Planning Consultation Memo

Date	Planning Officer	Environmental Health Officer
23/10/19	David Elmore	Karl Riahi
Planning Application Number	Worksheet Number	
6/2019/2313/FULL	WK/113050

Address: 101 Brookmans Avenue, Brookmans Park, Hatfield, AL9 7QG

Application Details: Erection of six dwellings following demolition of existing buildings

Drawing Title
PROPOSED SITE PLAN

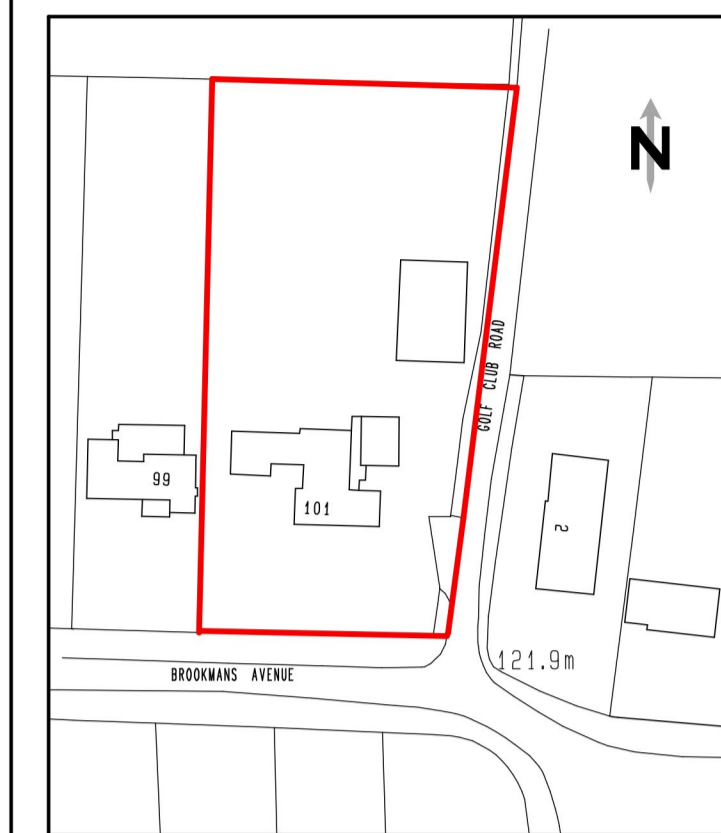
Information provided with the application shows a number of spot lights to be positioned around the proposed dwellings, the direction of which is not clear, although understood to be sympathetic to ecological concerns.

Prior to installation of external lighting the applicant shall submit to, for approval in writing by the Local Planning Authority, details relating to the external lighting scheme (including vertical lux diagrams which show potential light trespass into windows of nearby residential properties). This scheme must meet the requirements within the Institution of Lighting Professionals guidance notes for the reduction of obtrusive lighting.
